WEST SUSSEX COUNTY COUNCIL CONSULTATION

TO:	Arun District Council FAO: Simon Davis
FROM:	Highways, WSCC
DATE:	8 th June 2018
LOCATION:	Land West of, Fontwell Avenue, Eastergate, PO20 3RU
SUBJECT:	AL/50/18/PL Continuance of use without compliance with condition 10 imposed under AL/121/16/PL relating to vehicular access serving the development.
RECOMMENDATION:	OBJECTION
S106 CONTRIBUTION TOTAL:	£N/A

PROPOSED SITE PLAN 1:200

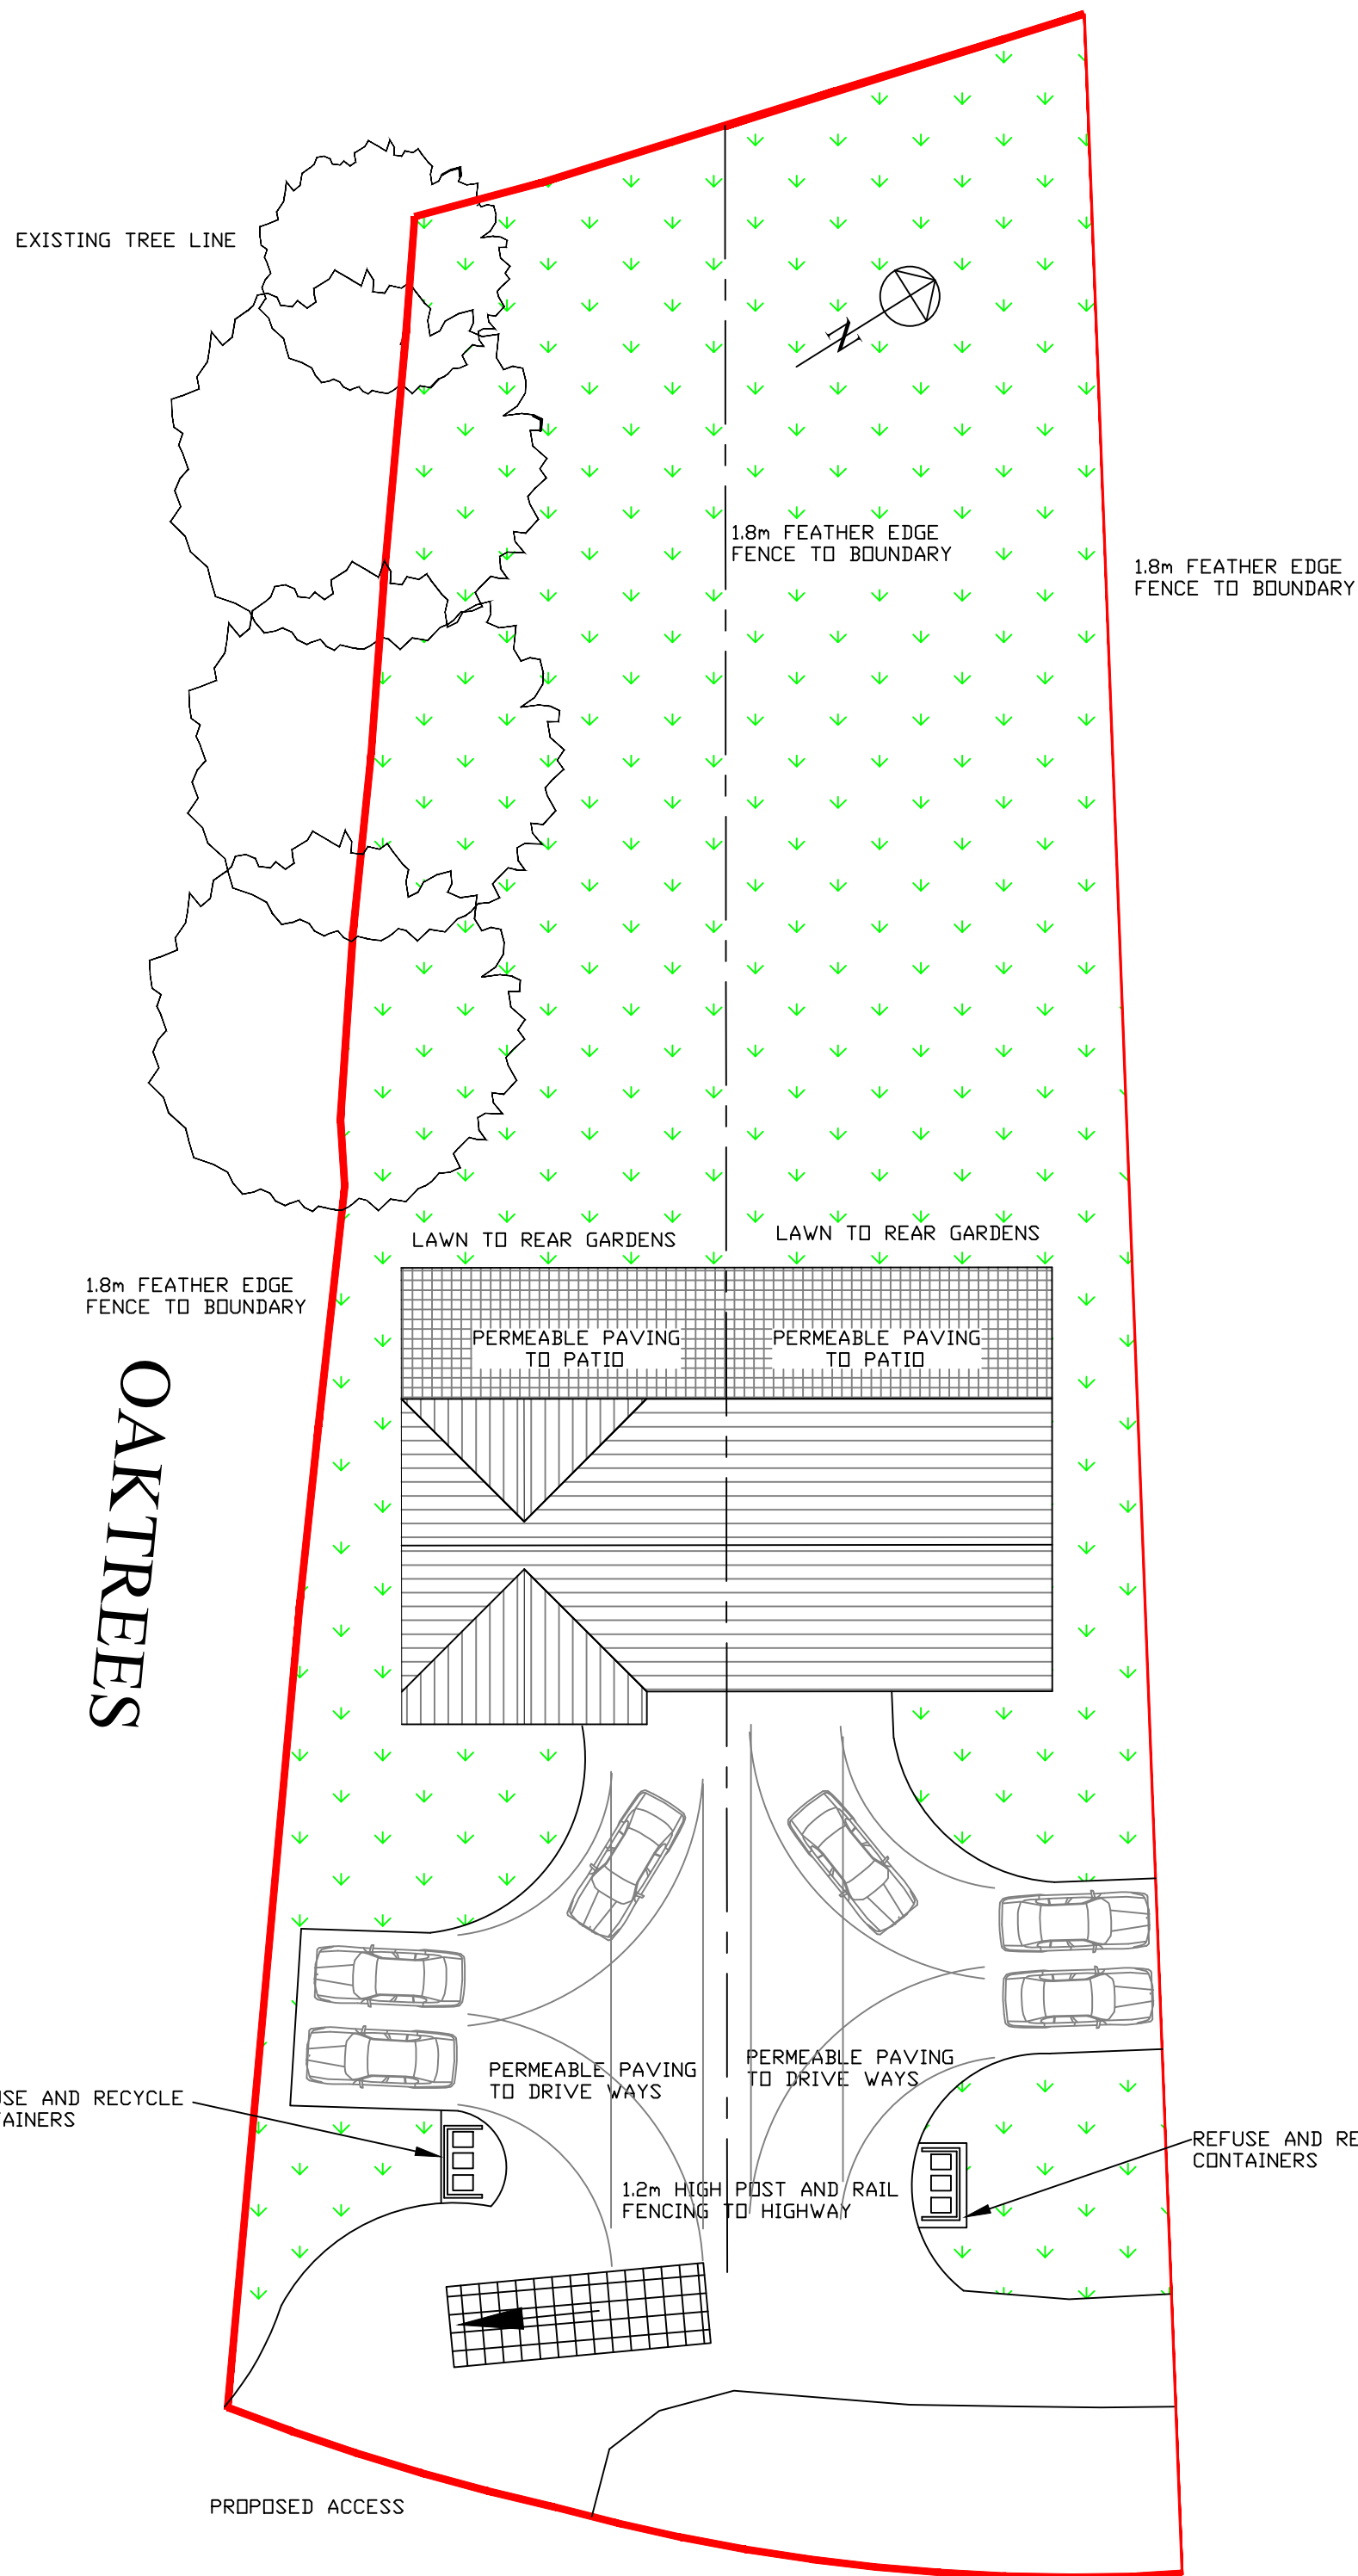
Currently, live application AL/136/17 seeks splitting of furthest south plot to provide 2 x semi detached houses and new second access to A29. Approval of this would result in a total of 6 x dwellings at the site and omission of the previously approved turning head in favour of an in/out dual access point arrangement.

require approval of proposed access arrangements under AL/136/17. It is understood that further information with regard to visibility splays and demonstration of turning are required under AL/136/17 to demonstrate the highway safety merits of this in/out access arrangement.

Until such time as the proposals under AL/136/17 have been demonstrated as 'safe and suitable' in line with paragraph 32 of the National Planning Policy Framework, the LHA are not in a position to support the non-compliance of condition application.
